Application No: P/86/20/PL
Site Address: Bowley Farm Bowley Lane South Mundham Chichester PO21 1NB
Description of works: Retention of 4 No. mobile homes for countryside workers together with drainage & service connection provision in connection with permission P/72/09 as varied by P/22/17/PL. This application in in CIL Zone 5 (Zero Rated) as 'other development'.

Thank you for your internet representation made on 2nd October 2020 which has been recorded as an objection with the comments as follows:

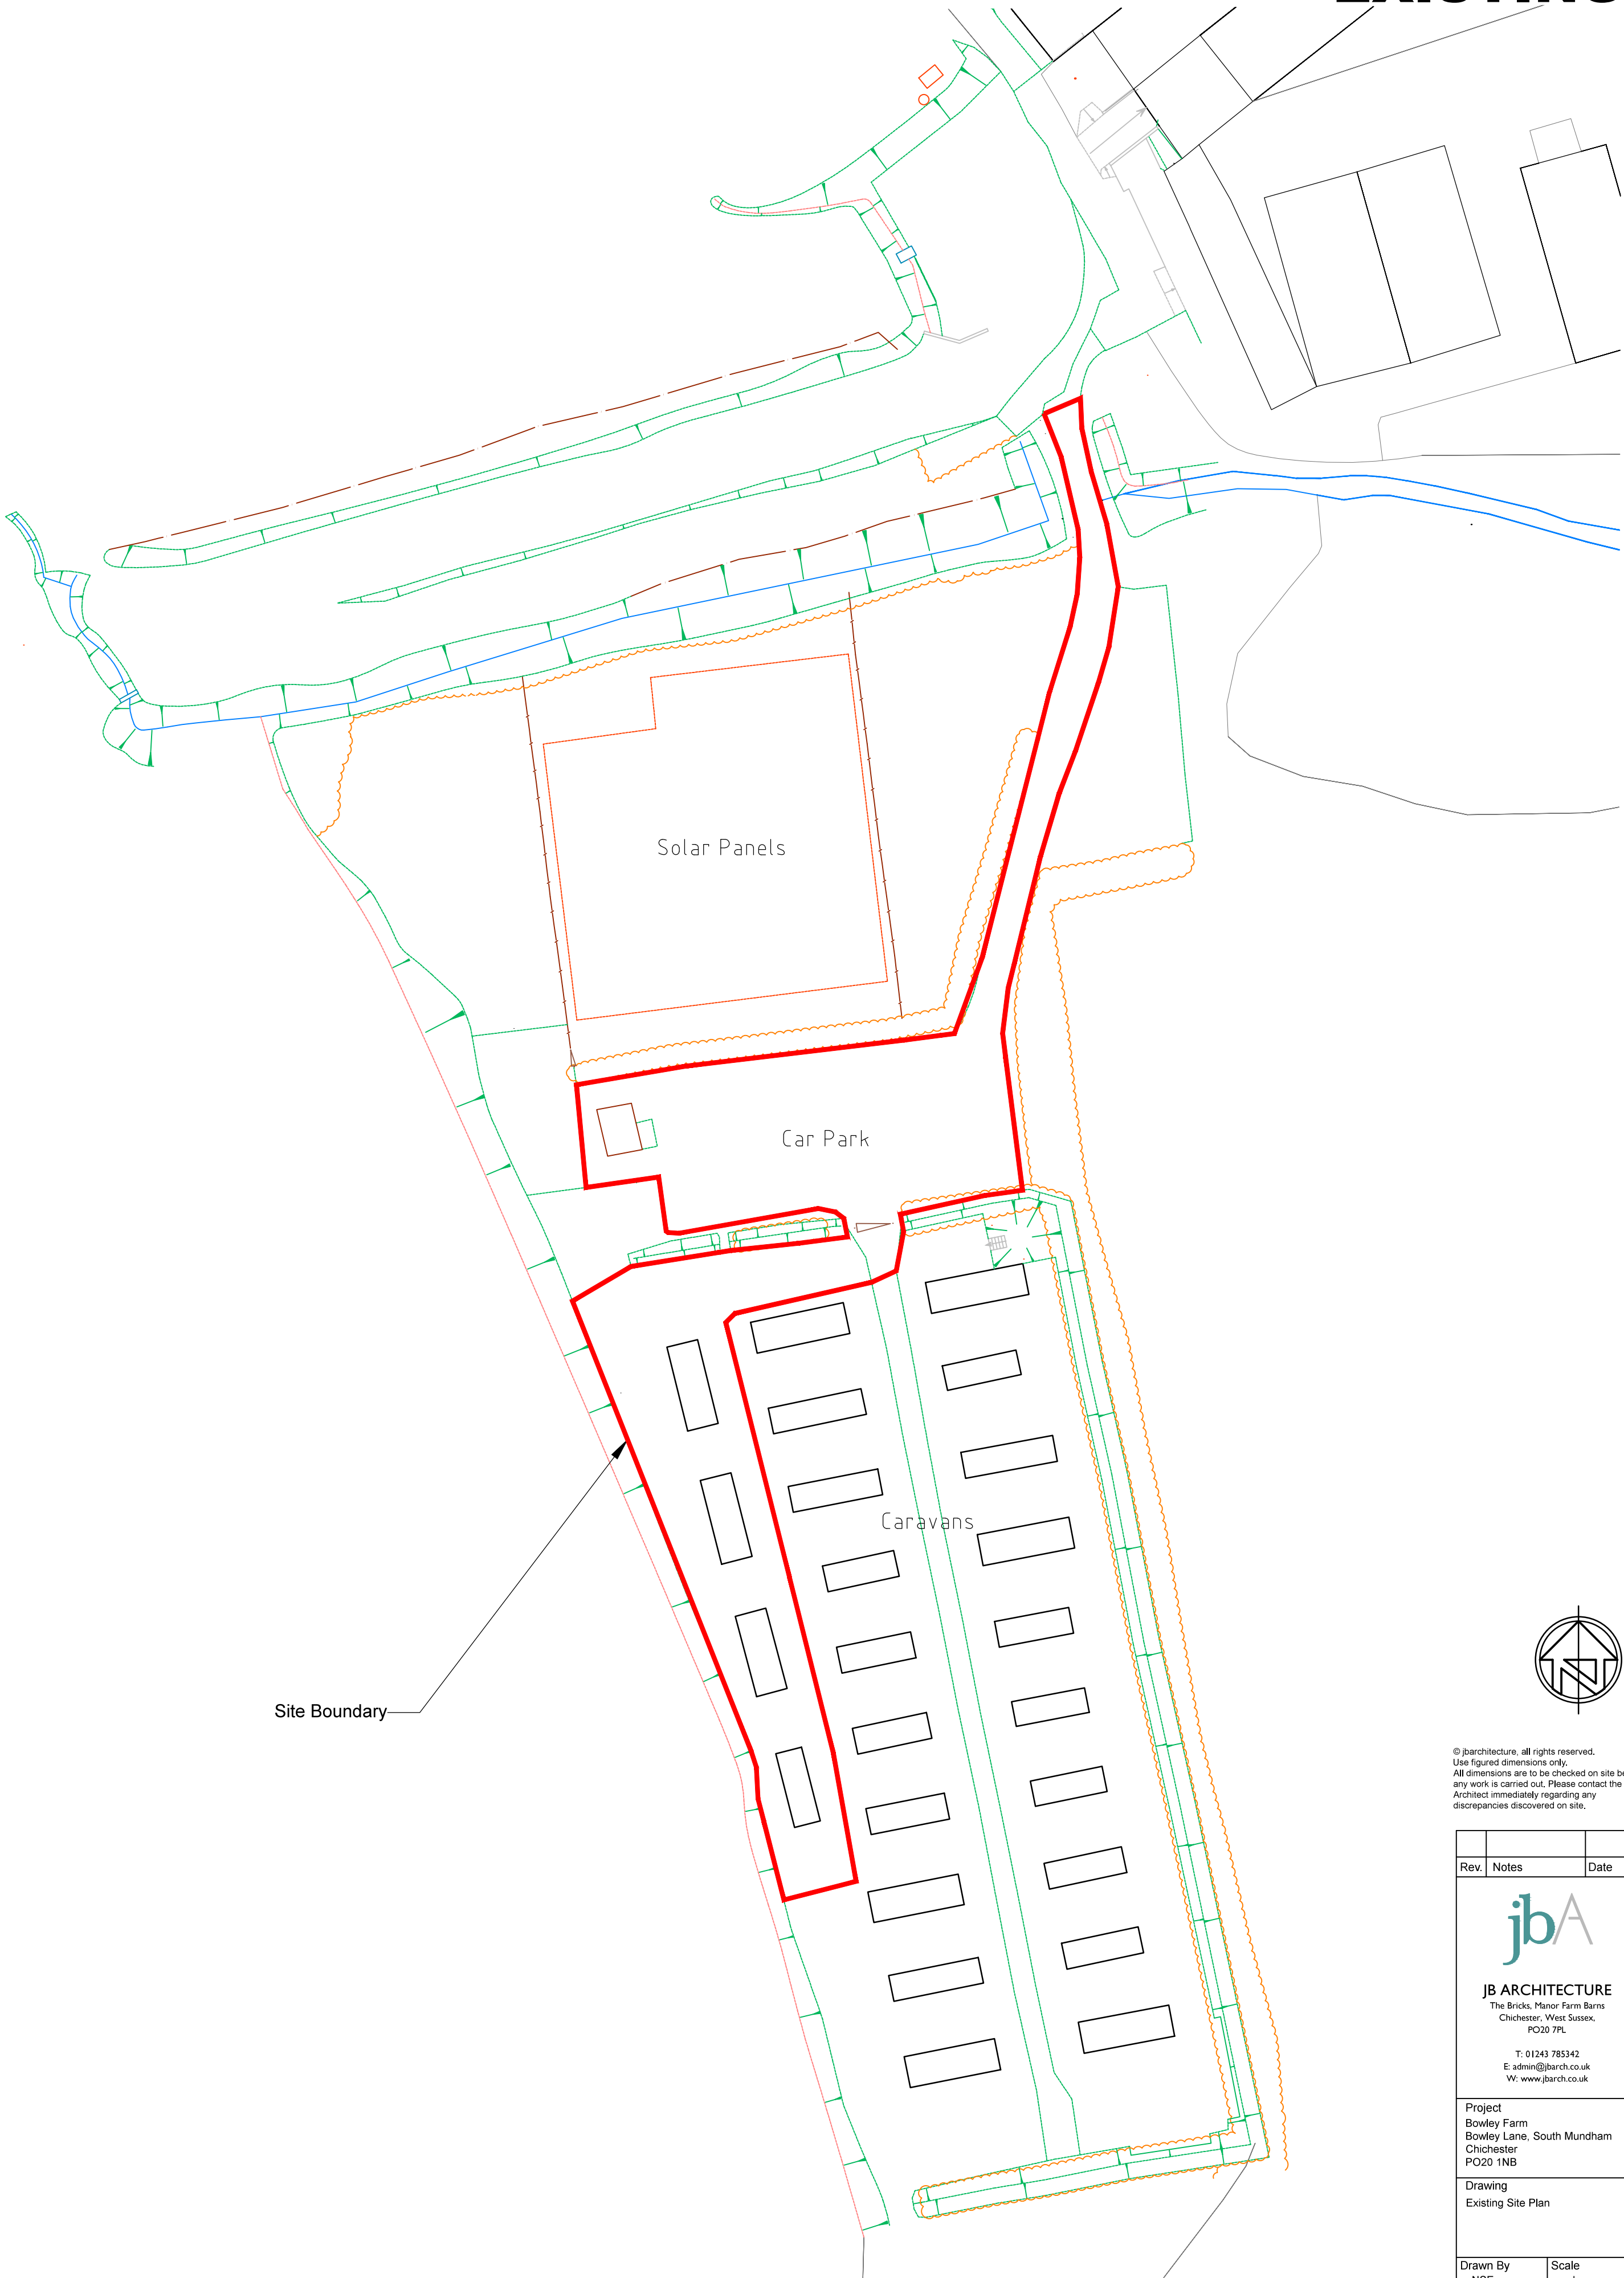
In addition, I query the number of caravans at Bowley Farm as related to the site plan provided. There are more than 24 onsite. Can you confirm the exact number?

In summary, traffic volume and speed is already a major issue on Bowley Lane. I would not be surprised if a major accident occurs in the near future as a consequence. There are more than 24 caravans on the Farm so I strongly suggest someone make a site inspection to ascertain how many there are. Residents are not onsite on a seasonal or temporary basis.
